14 March 2025

Re: MODIFICATION 3 TO SSD-44034342 – Landscape Architectural Advice for Integrated Mental Health Complex

Site Image has undertaken updates to the following landscape documentation reflecting the following architectural changes

DRAWING TITLE  
LANDSCAPE PLAN  
GROUND

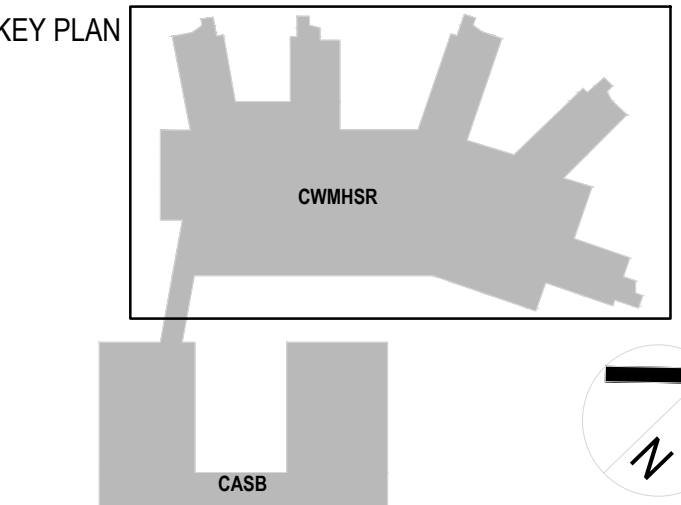
Drawing / Page	Revision reference		Revision
		Landscape SSDA Report	
0011 Ground Floor	L-1	Seating deleted	L
0011 Ground Floor	L-2	Extent of sandstone reduced	L
0011 Ground Floor	L-3	Updates to seating nodes and Ceremony area, 2 shelters deleted	L
0012 Ground Floor	L-4	Shelter deleted	L
0012 Ground Floor	L-5	Updates to seating wall and BBQ in Staff Courtyard	L
0012 Ground Floor	L-6	Adjustment to paving extents	L
0014 Level 1	L-7	Green Roof removed	L
0014 Level 1	L-8	Pot deleted from de-escalation courtyard	L
0016 Level 1 Courtyard	L-9	Planter size reduced, BBQ deleted, seating walls reduced and bench seats reduced. Pot deleted from de-escalation courtyard	L
0017 Level 2 Courtyard	L-10	Planter size reduced. BBQ deleted, fixed furniture repositioned.	L
0017 Level 2 Courtyard	L-8	Pot deleted from de-escalation courtyard	L
0017 Level 2 Courtyard	L-11	Planter size reduced, seating walls and bench seating updated	L

LANDSCAPE PLAN  
LEVEL 2

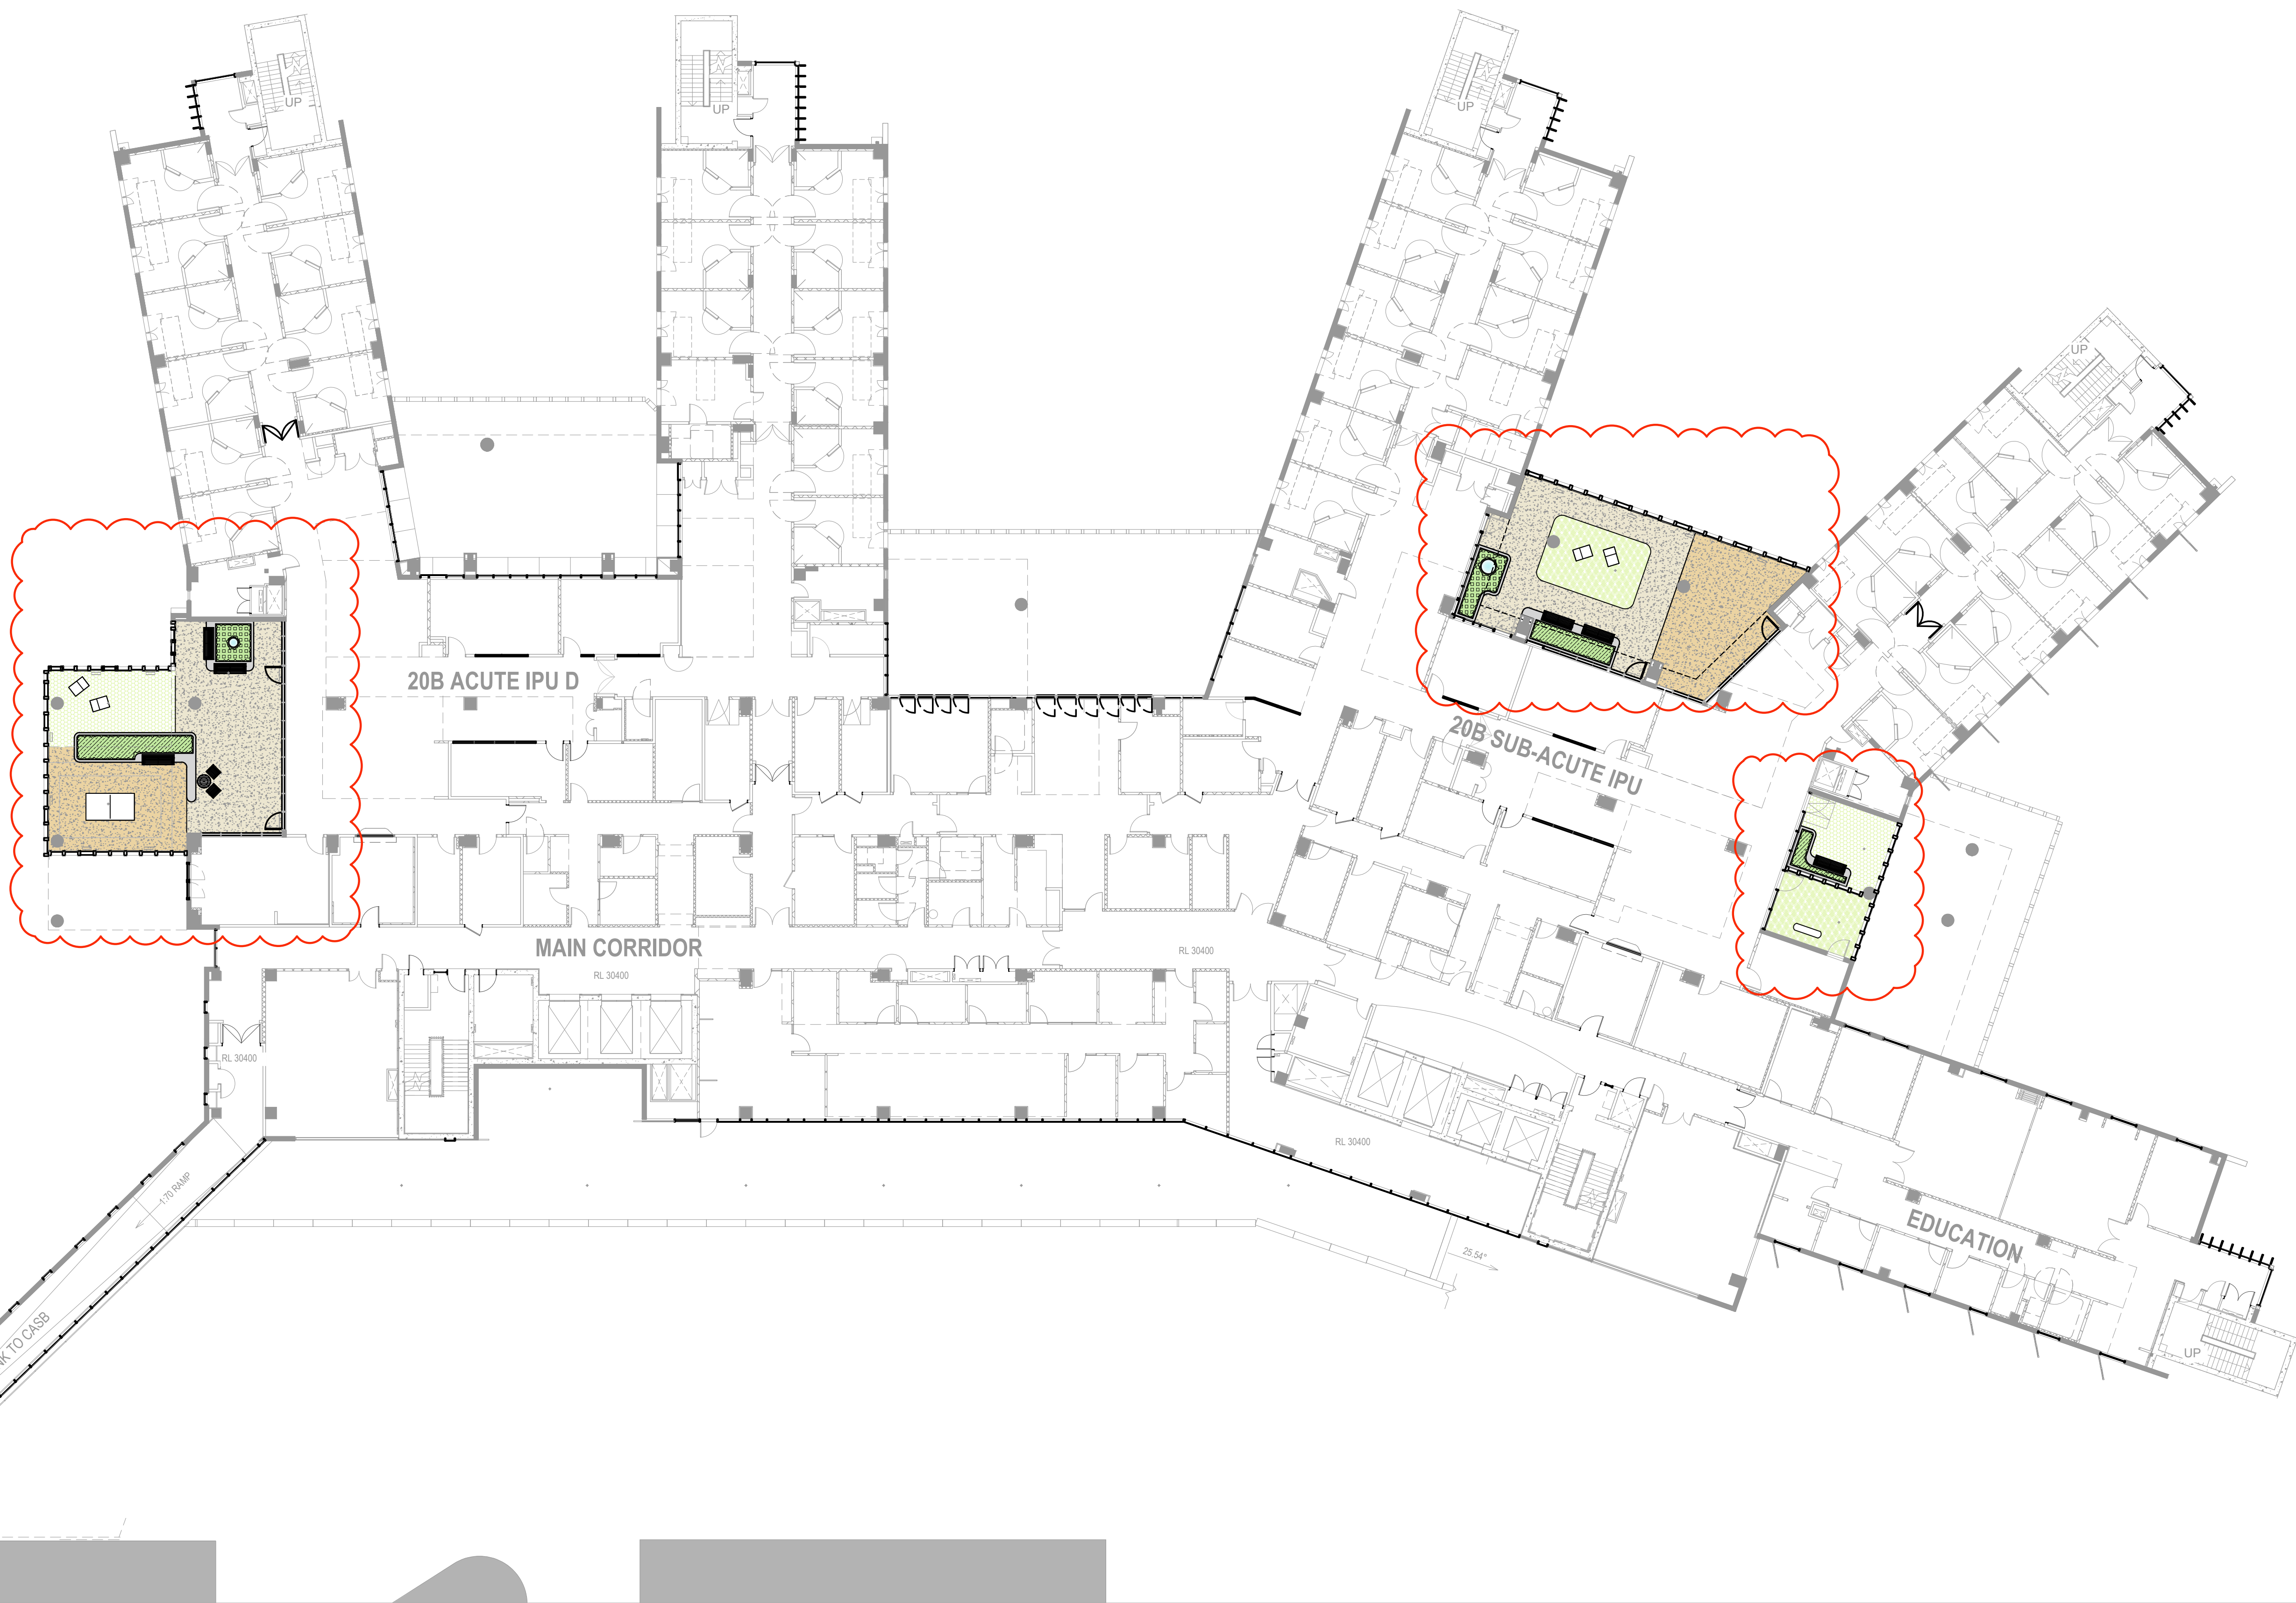
IMHC_LS_DG_0120 Landscape Plan Level 2		Planter size reduced. BBQ deleted, fixed furniture repositioned. Pot deleted from de-escalation courtyard Planter size reduced, seating walls and bench seating updated Planter size reduced. BBQ deleted, fixed furniture repositioned.	6
IMHC_LS_DG_0130 Landscape Plan Level 3		Planter size modified, BBQ deleted, 5 seats and 2 tables deleted. BBQ and planter deleted, seating walls reduce Courtyards relocated from northern facade, Pots deleted	7
IMHC_LS_DG_0140 Landscape Plan Level 4		BBQ Deleted Pot deleted from de-escalation courtyard	7

LANDSCAPE PLAN  
LEVEL 5

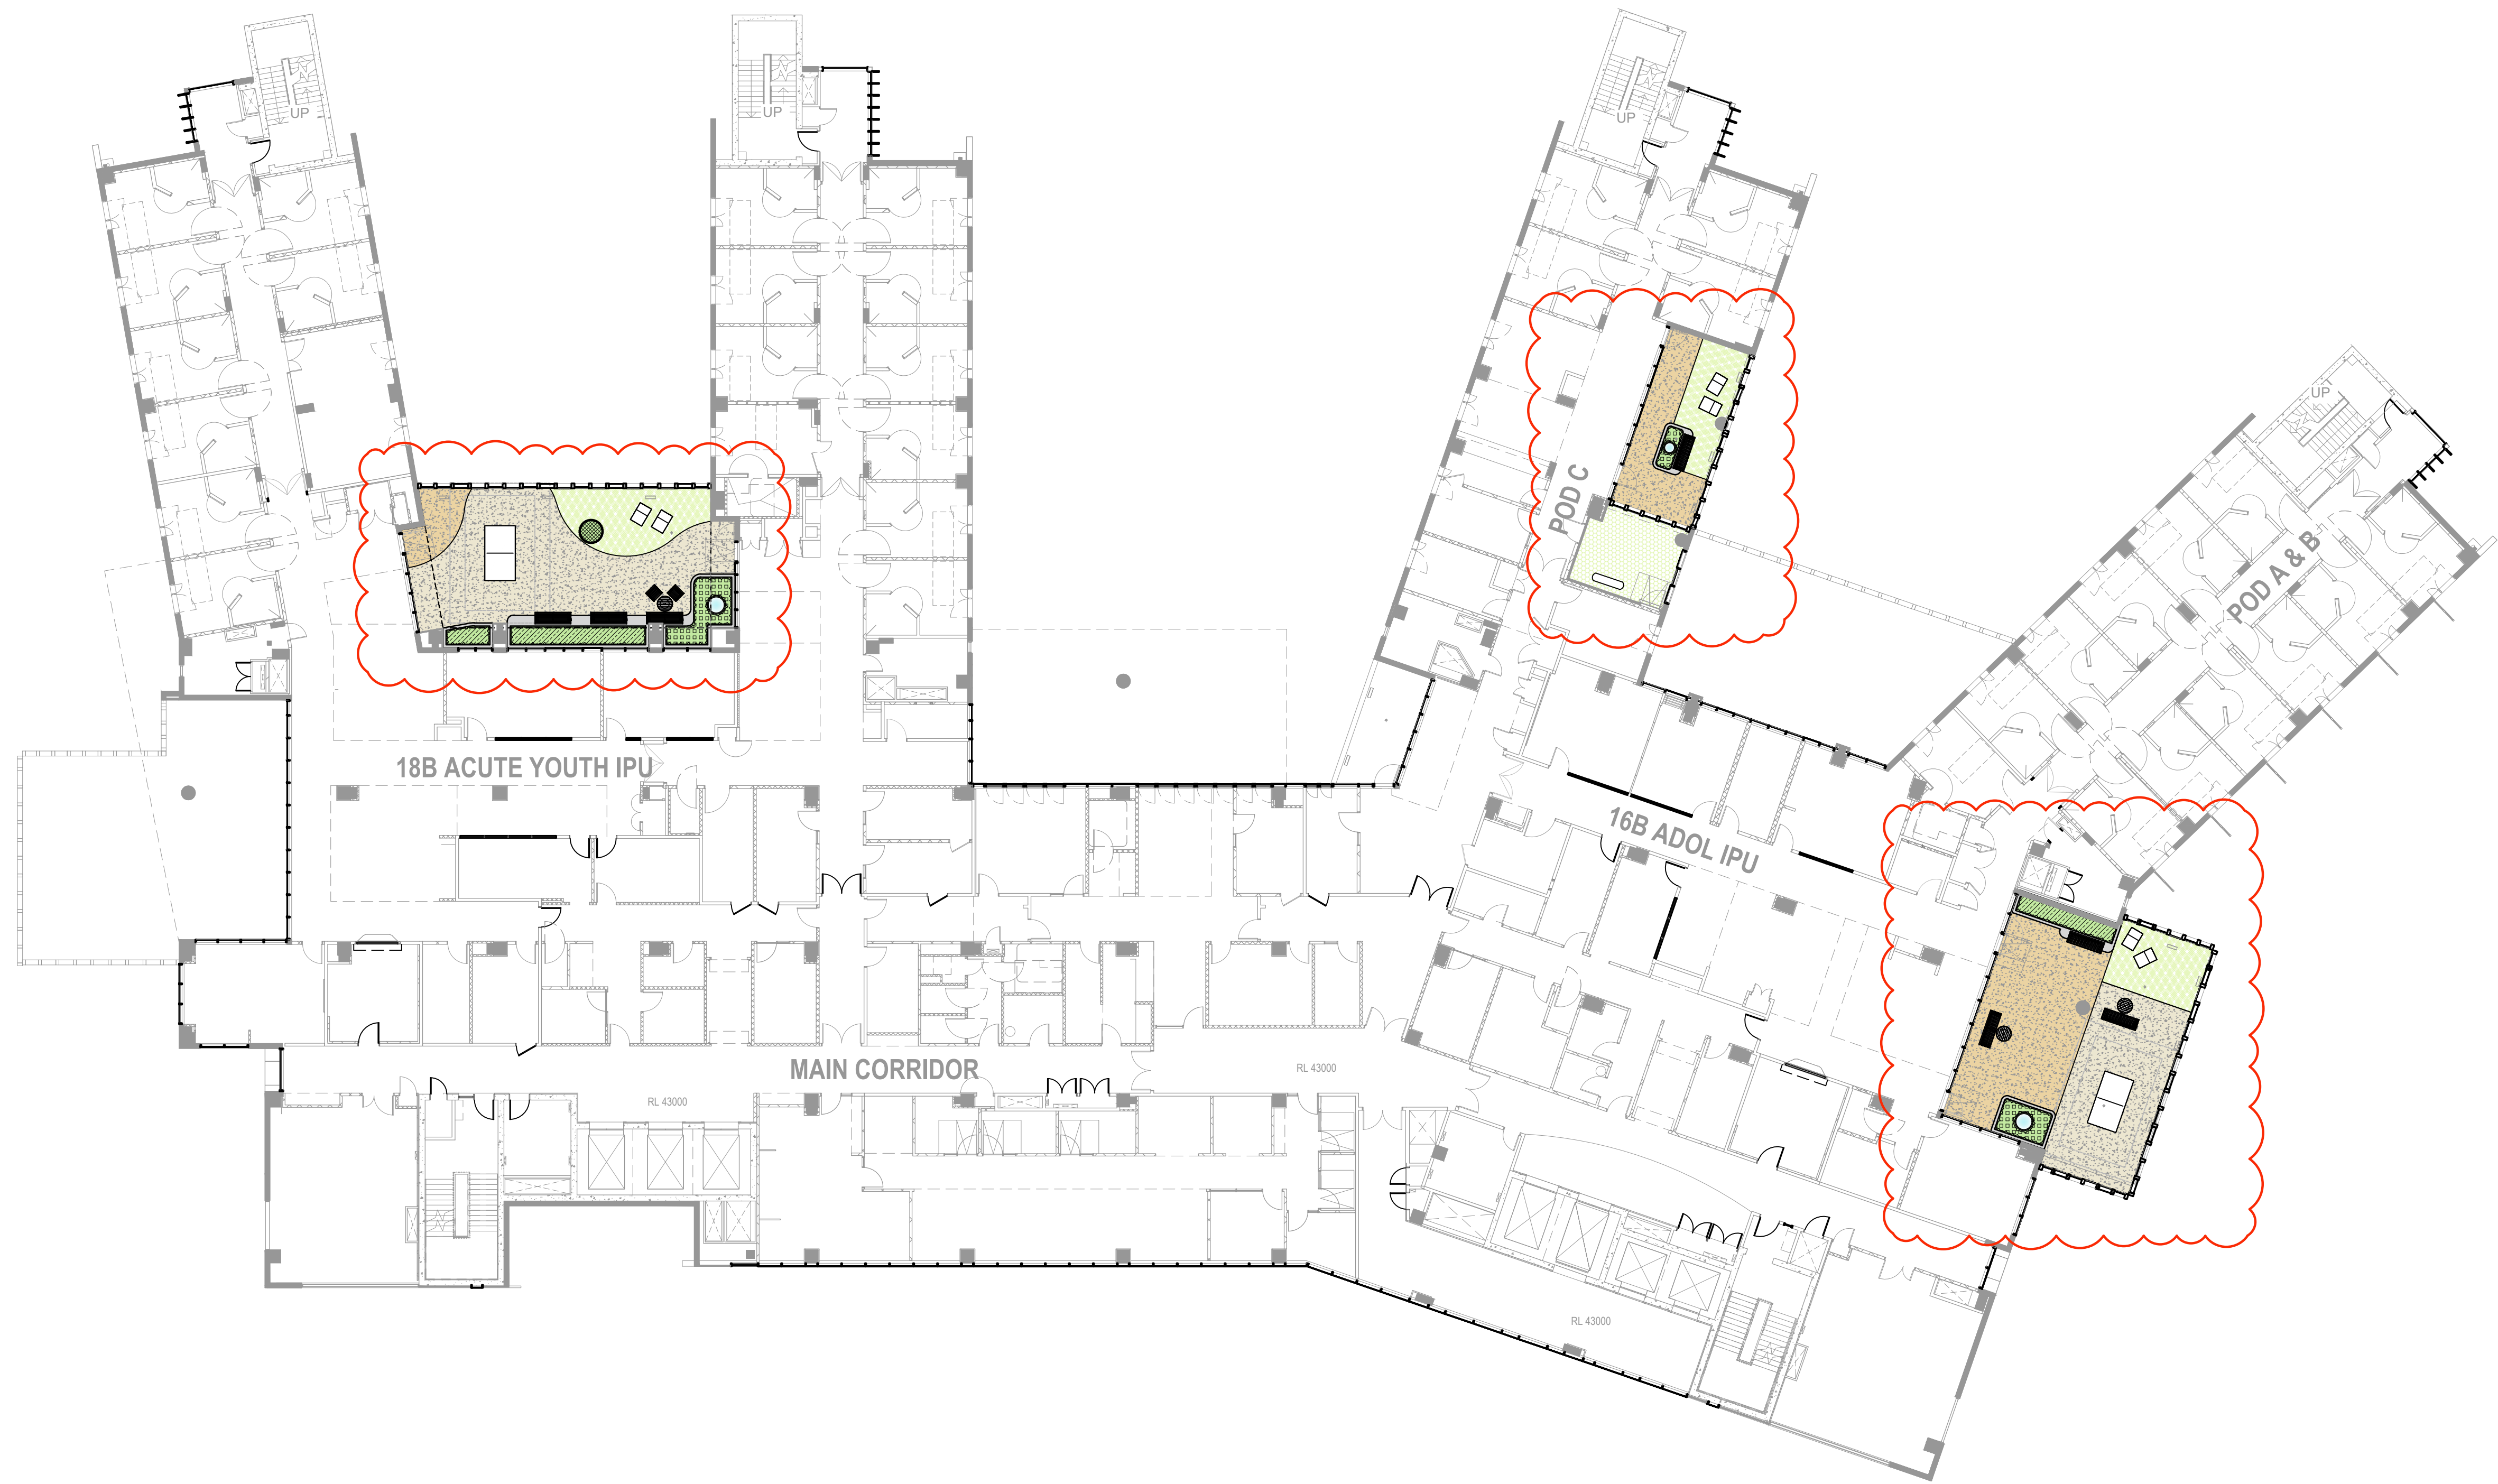
IMHC_LS_DG_0150 Landscape Plan Level 5	Planter size modified, 2 bench seats deleted BBQ deleted, planter reduced and 3 cafe tables deleted. BBQ deleted, planter reduced, 1 x table and chair set deleted.	6
IMHC_LS_DG_0160 Landscape Plan Level 6	BBQ Deleted BBQ deleted, planter reduced Courtyard relocated, pot deleted BBQ deleted, planter and seating wall reduced, Artificial turf size reduced	7
IMHC_LS_DG_0170 Landscape Plan Level 7	Pot deleted Furniture relocated, 1 cafe seating deleted, planter size modified 2 bench seats deleted, planter reduced, BBQ deleted, 1 table deleted 2 bench seats deleted, planter reduced, BBQ deleted, 1 table deleted	7
IMHC_LS_DG_0180 Landscape Plan Level 8	BBQ deleted, planter reduced, pots deleted. Pot deleted from de-escalation courtyard BBQ deleted, planter size modified, bench seats added, cafe seating added	6
IMHC_LS_DG_0190 Landscape Plan Level 9	Artificial turf reduced, bench seats added Layout updated, planter beds modified, table and seats added	6
